Re: 31 Fore St Plat

The plat has been reviewed by the various departments and we would request revisions to address the following comments:

DRAWING NO.
SP-1

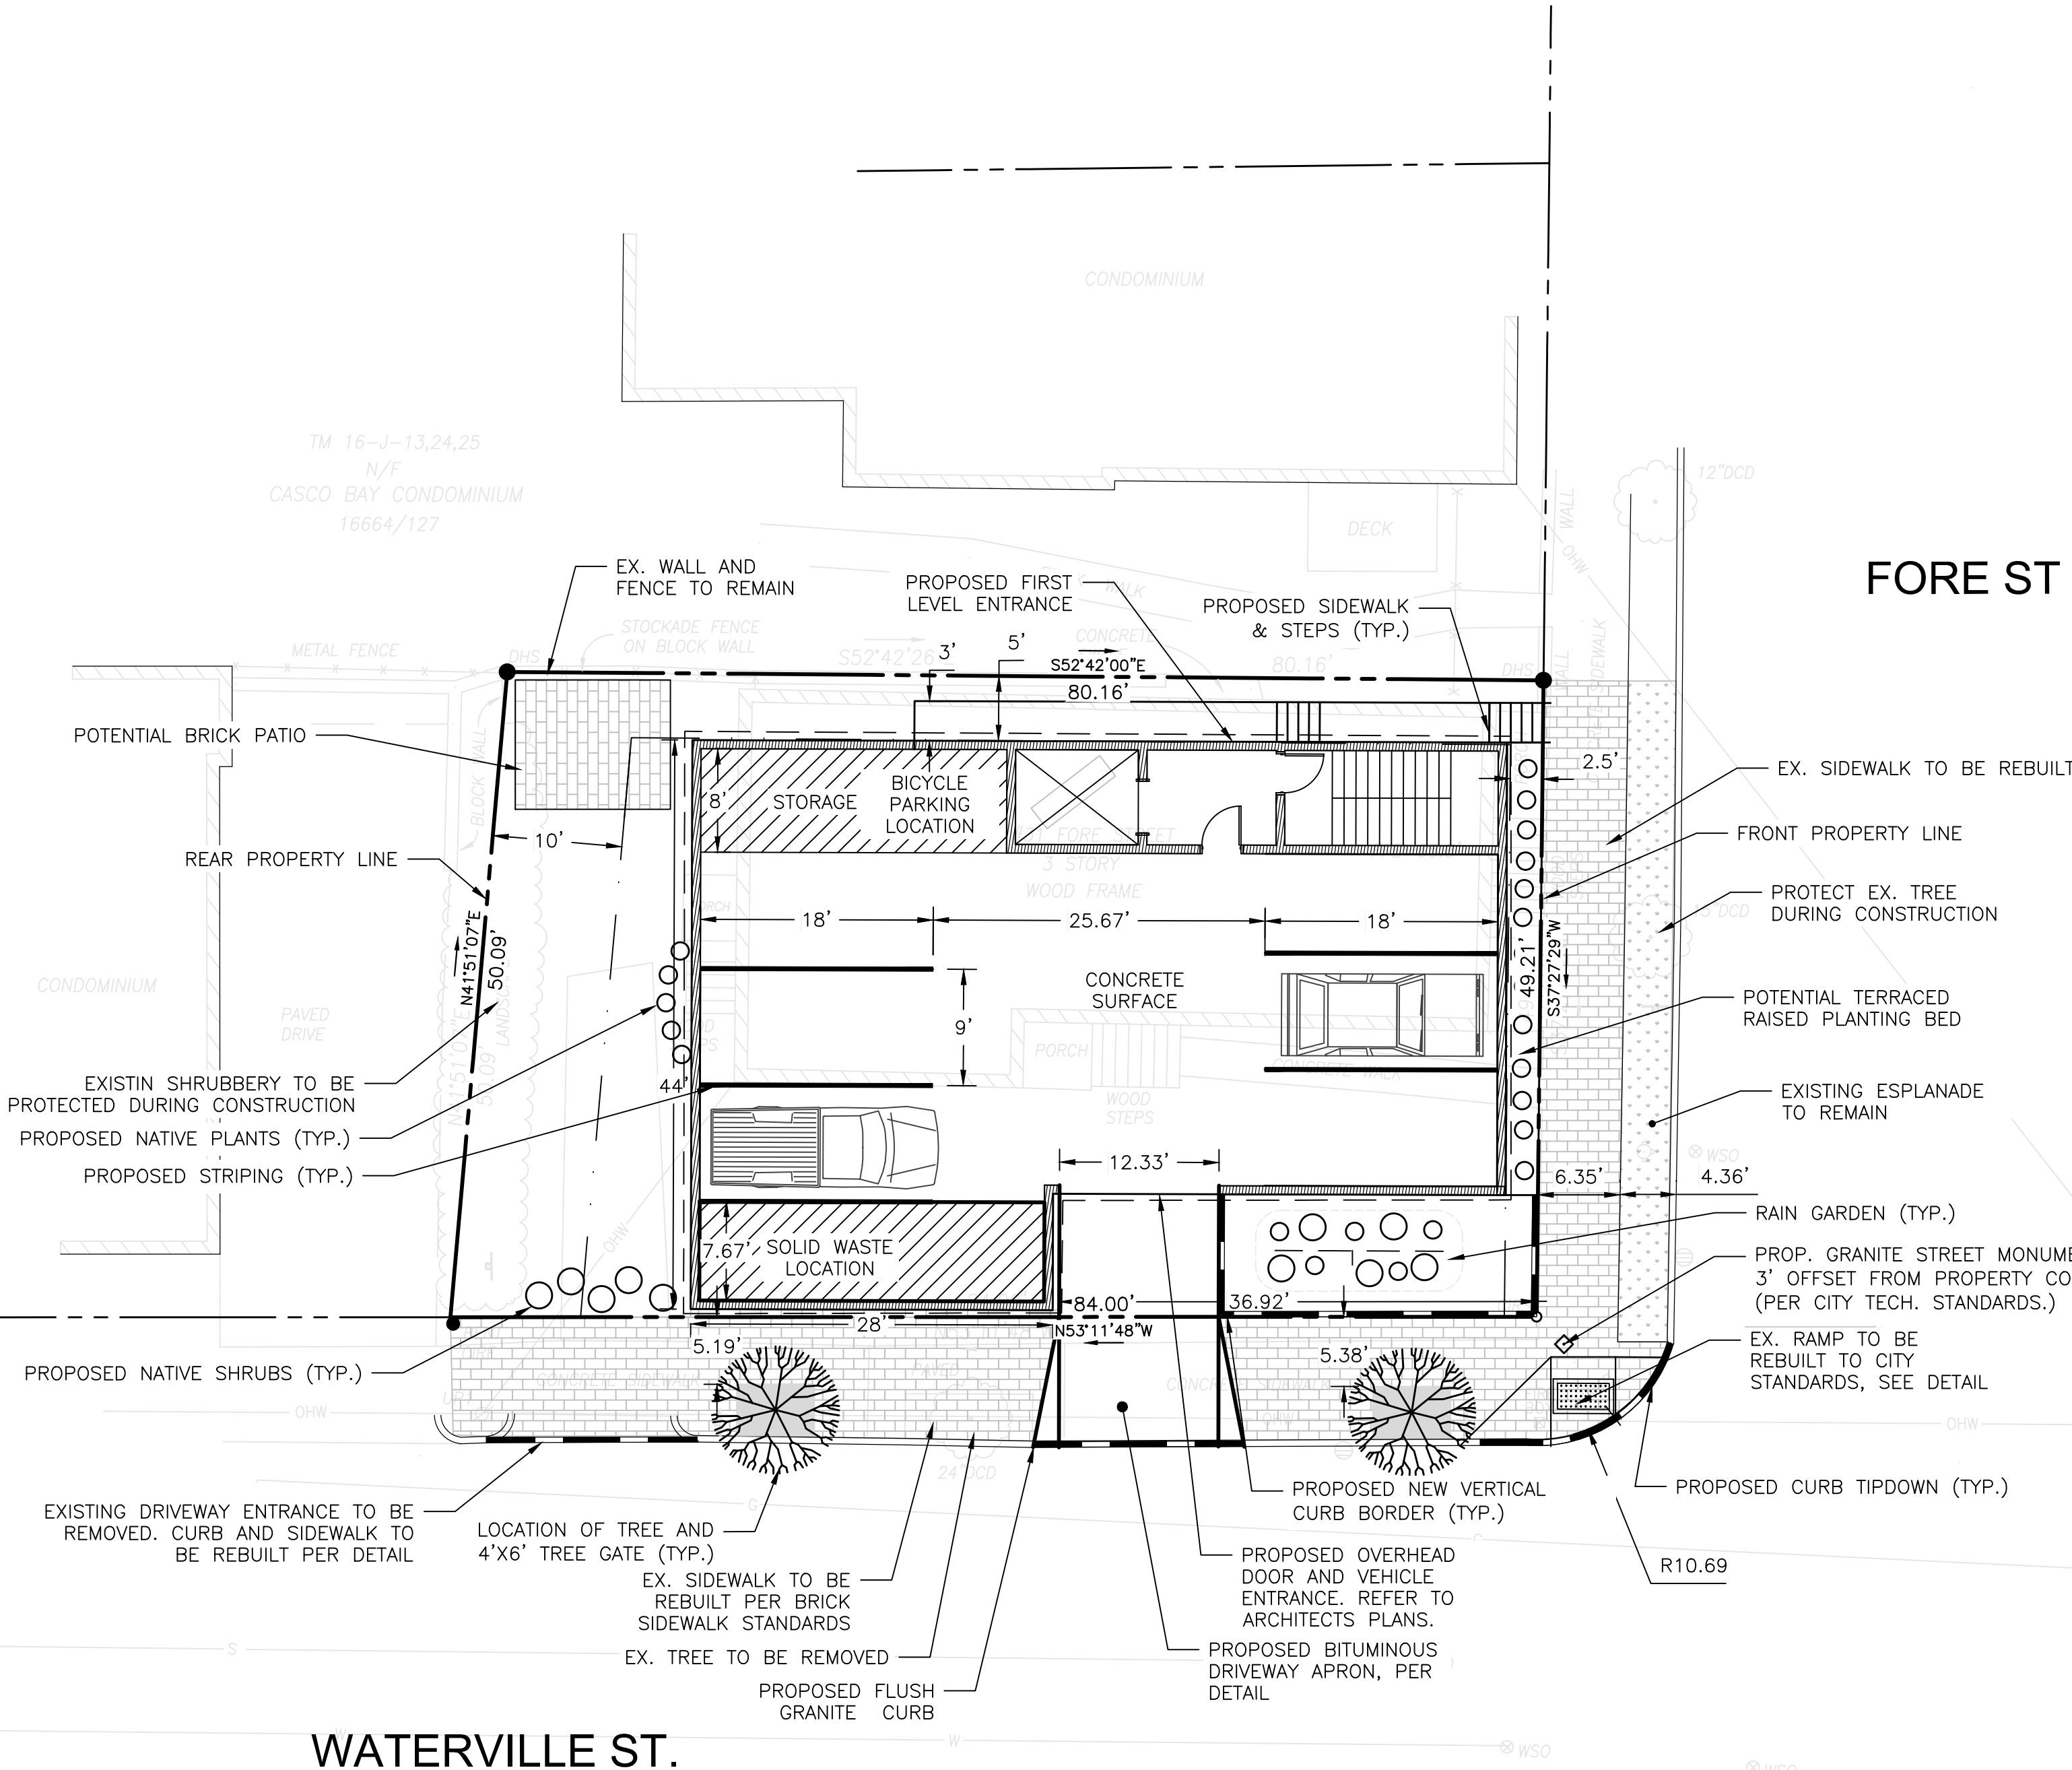
- Survey comments:
 1. The location of the monument, and the notation on the plan about the location of the street monument (3 feet from the property line corner), are incorrect and should be changed. The notation should state that the center of the monument shall be set at the intersection of a line offset 3-feet from the right of way line on Waterville Street and a line offset 3-feet from the right of way line on Fore Street.

2. The coordinates of the proposed street monument should be listed on the plat.
 3. The recording plat should be stamped (or sealed) by a professional land surveyor.

4. The subdivision corners on the plat should be marked as follows: "iron rods to be set," (or other suitable monumentation). The corner monumentation should be set, which can be done after the plat is recorded.

- Please add note to each of the new street trees in Waterville, that the

applicant is installing, "New street tree and treewell to be installed by applicant" (to avoid confusion vis a vis the waiver).

- General Note #8 should include the book and page for both of these recorded documents (leave blanks and these can be filled in by hand just before the plat is recorded); also Site Plat Note #7 should refer to the condo documents and Site Plat Note #8 should refer to the Stormwater Maintenance Agreement.

- Not sure about the distinction between General Notes and Site Plat notes- maybe make all one list of 16?
- Please put the PB waivers and conditions of approval in a box labeled with larger letters "Planning Board Waivers and Conditions of Approval 3.22.2016" and leave out all of the "site plan" conditions except 2 (CMP), 3 (Mechanicals), 4 (protection of street tree) & 6 (on street parking changes) as all of the others need to be addressed on the final plans which need to be submitted for review and approval before the plat is released for recording (some sooner as noted above);
- Please correct typos in the waivers (the paraphrasing is OK);
